MEMORANDUM

To: FILE
From: Jean Fraser
Subject: Application ID: 2015-058
Date: 5/6/2015

Comments Submitted by: Keith Gautreau/Fire on 5/6/2015

SITE PLAN

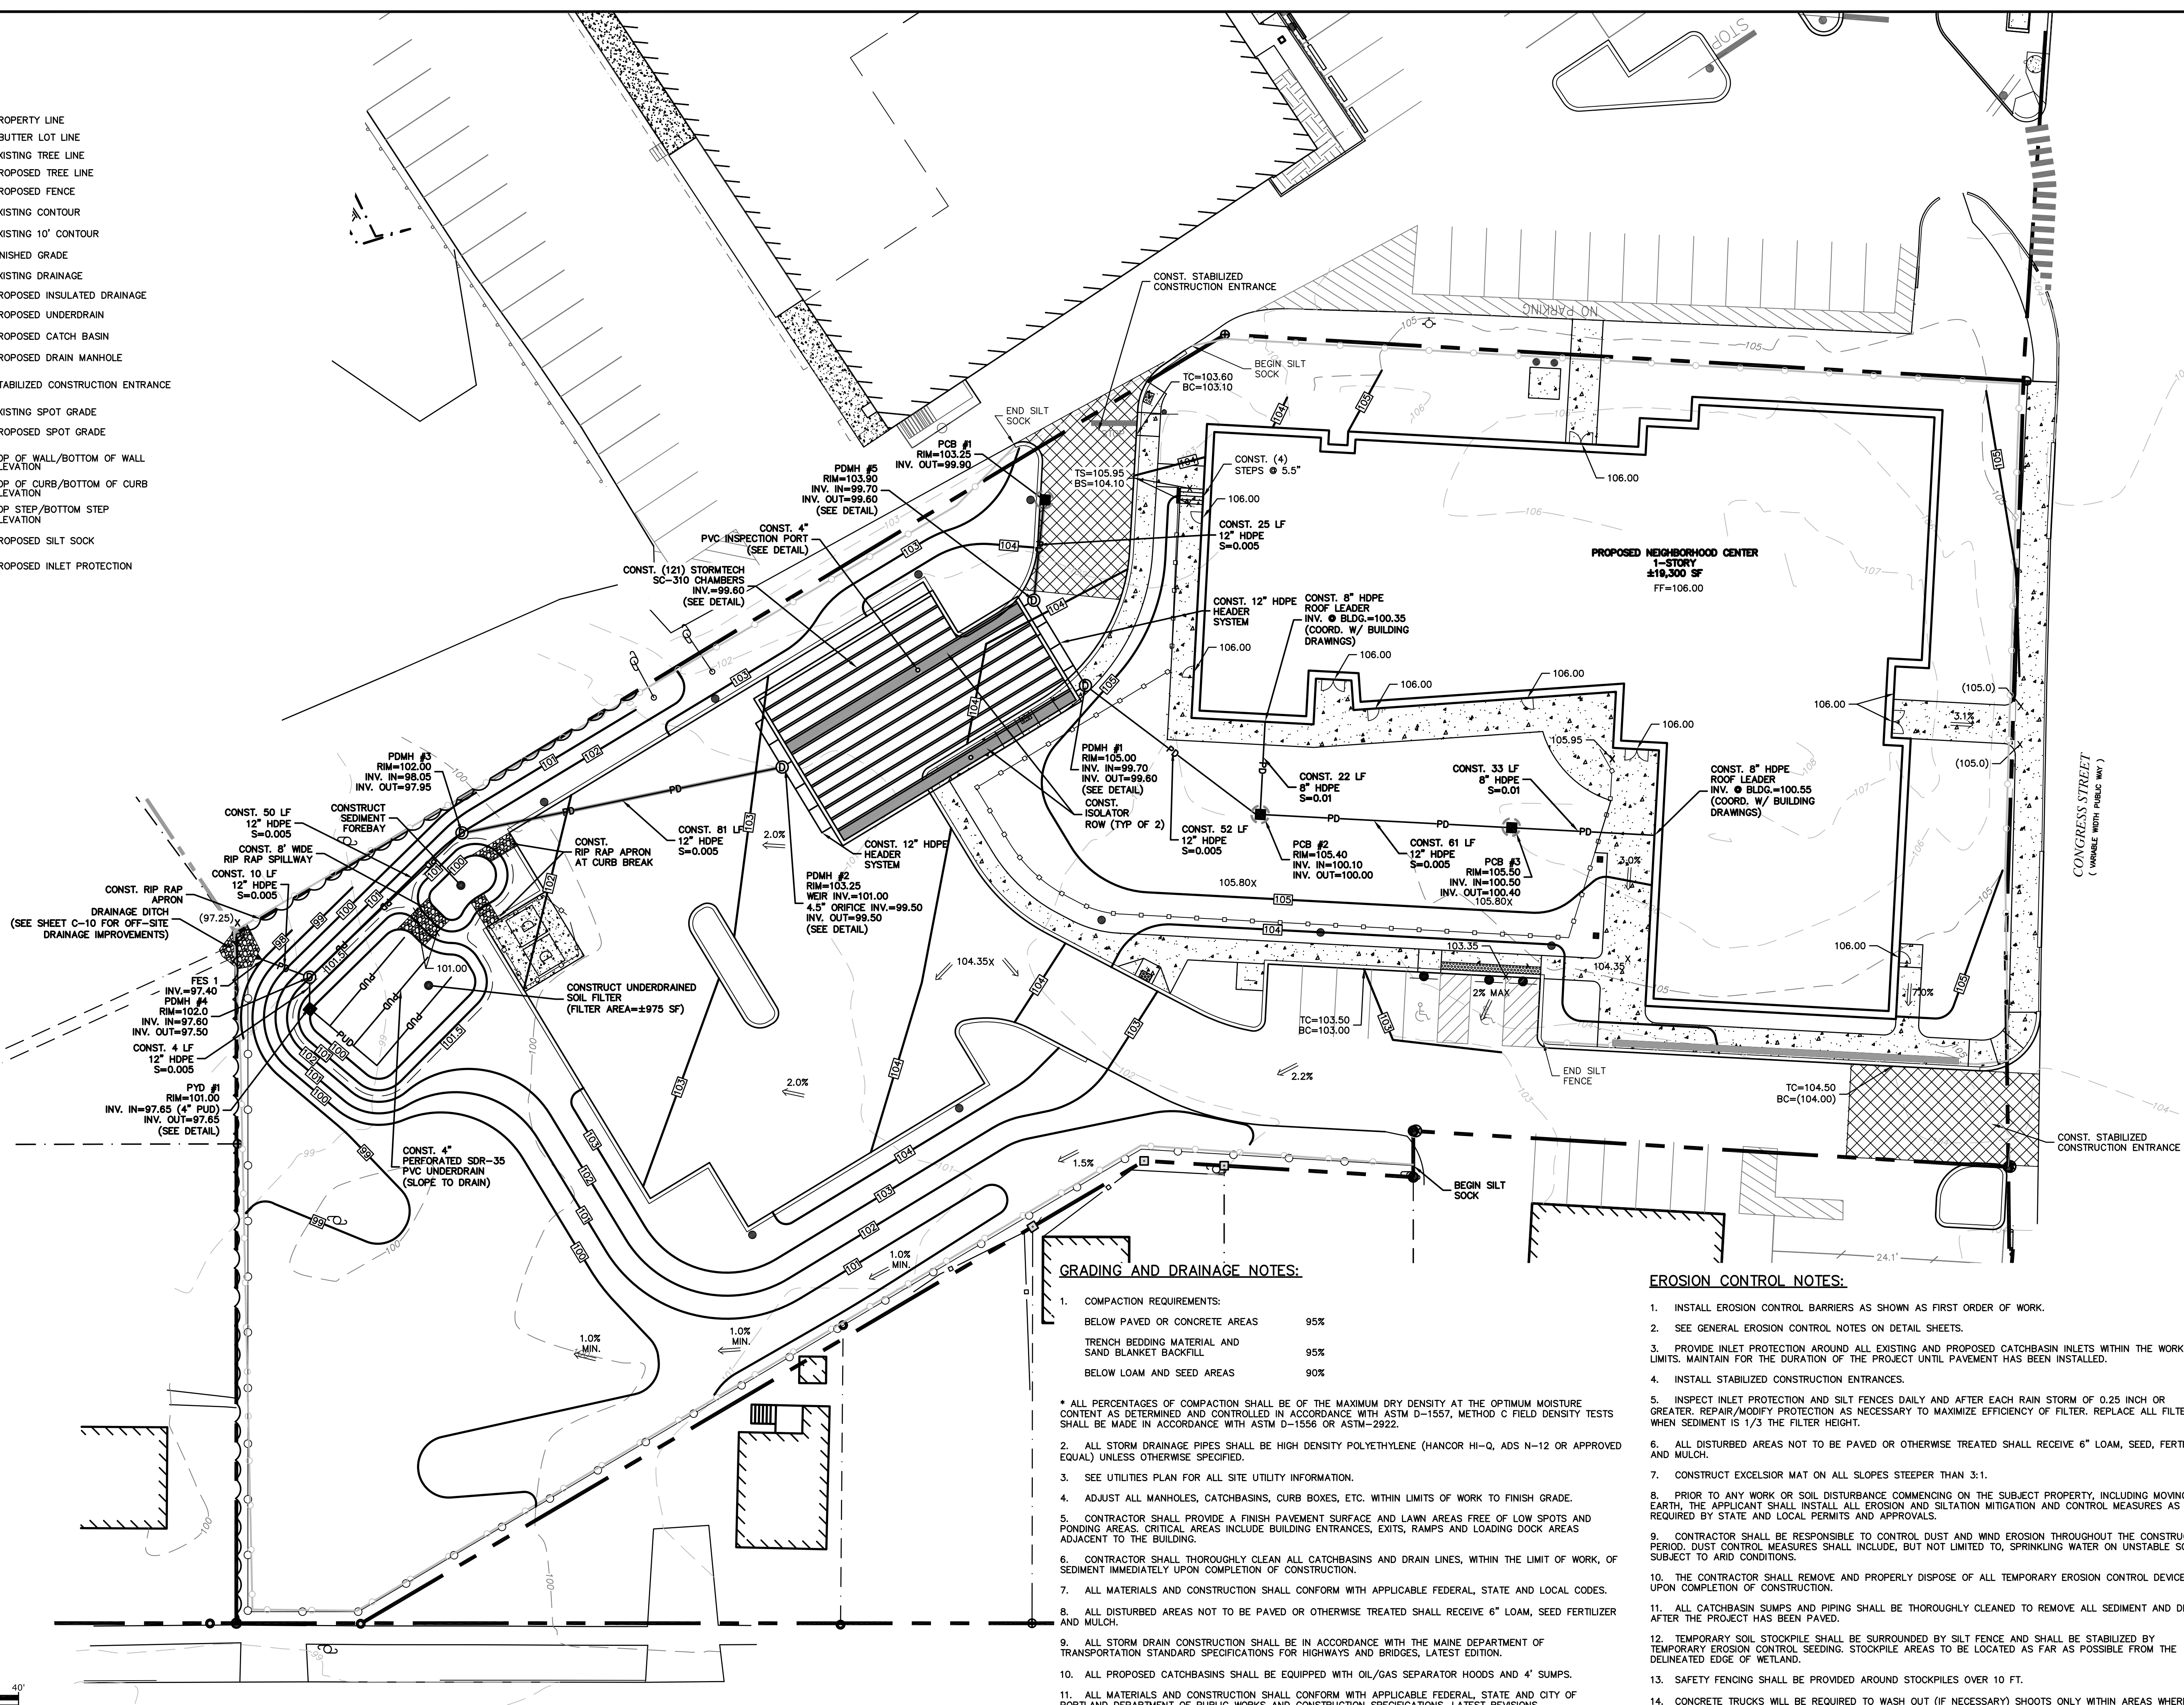
Streets must maintain a 20' width for Fire Department access at all times.

Fire Hydrants shall not be blocked or enclosed by fencing. A 3' foot clearance must be kept at all times around the fire hydrant.

1.) Largest Fire Department Vehicle must be able to navigate through the parking lot to access building.

2.) Fire Department Access shall have an unobstructed vertical clearance of not less than 13 ft 6 in.

The new building shall not affect the egress or required Fire Department access for the neighboring building.

-Fire Department Connections shall not be located where large diameter hose may block egress.
